Rustington Parish Council

Our ref: CW/CH/PLAN/11
Date: 14 April 2011

R/51/11 - Application for outline planning permission with some matters reserved for demolition of existing dwellings and construction of 11 No. apartments with parking and access. Re-submission following R/213/10 - 2 and 4 Broadmark Lane and 18 Vernon Close, Rustington

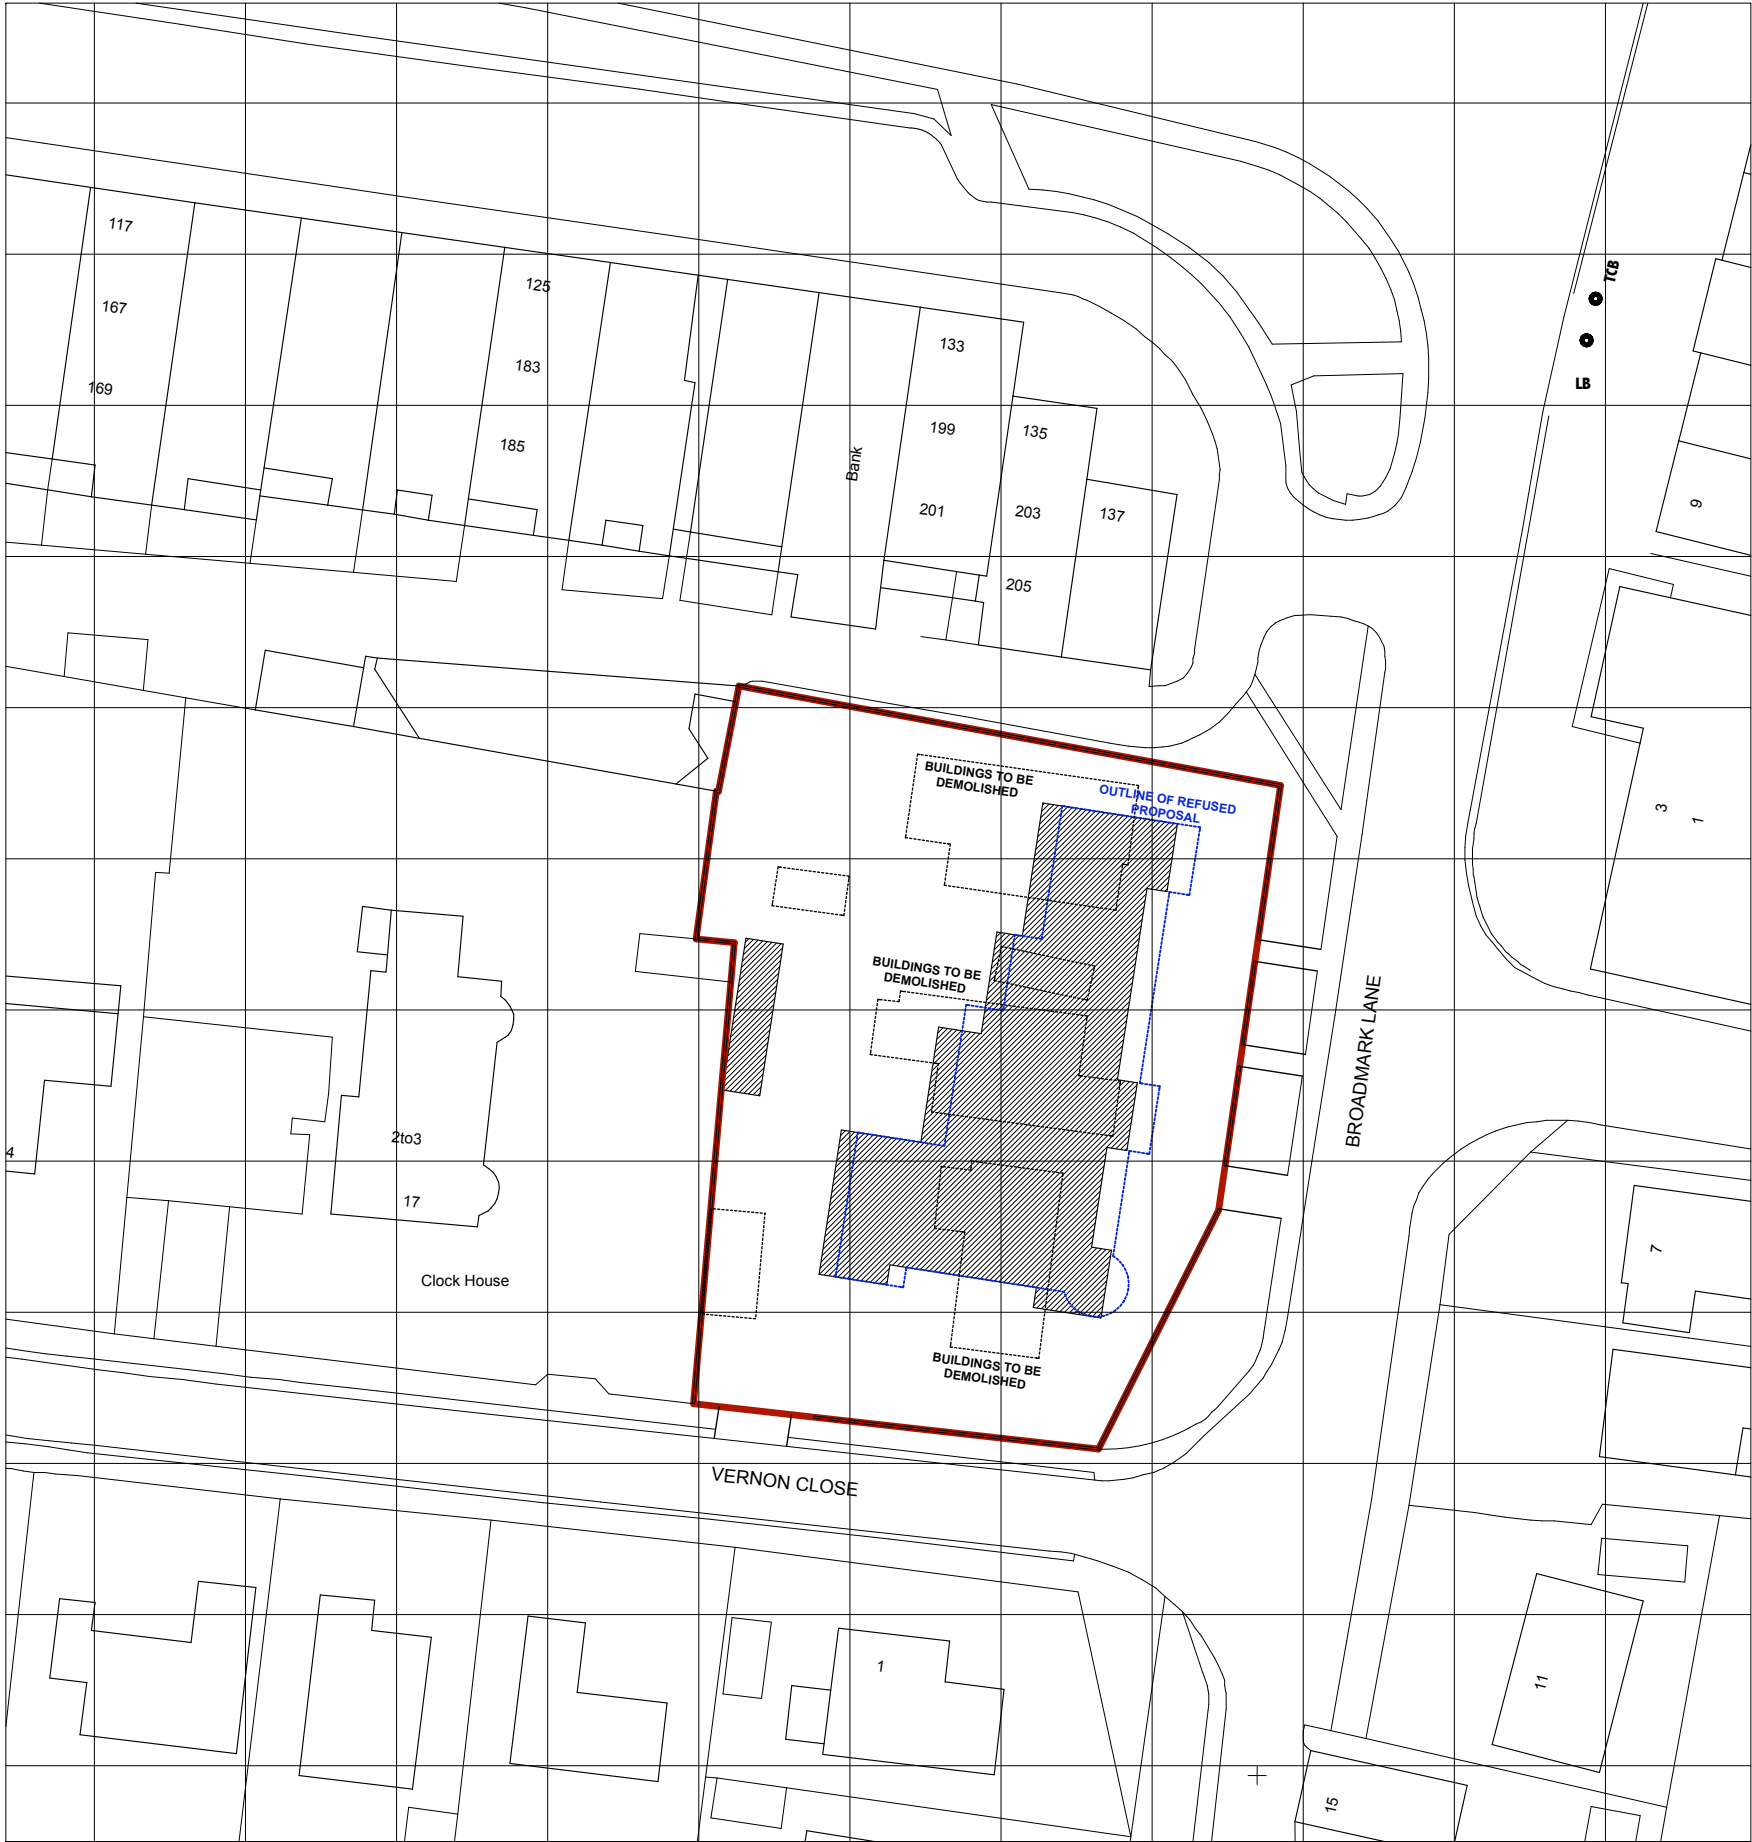
- (g) The East elevation (front) of the proposal front is forward of the visually important building line created by the existing line of No. 137 The Street to No. 1 Vernon Close (see Block Plan)
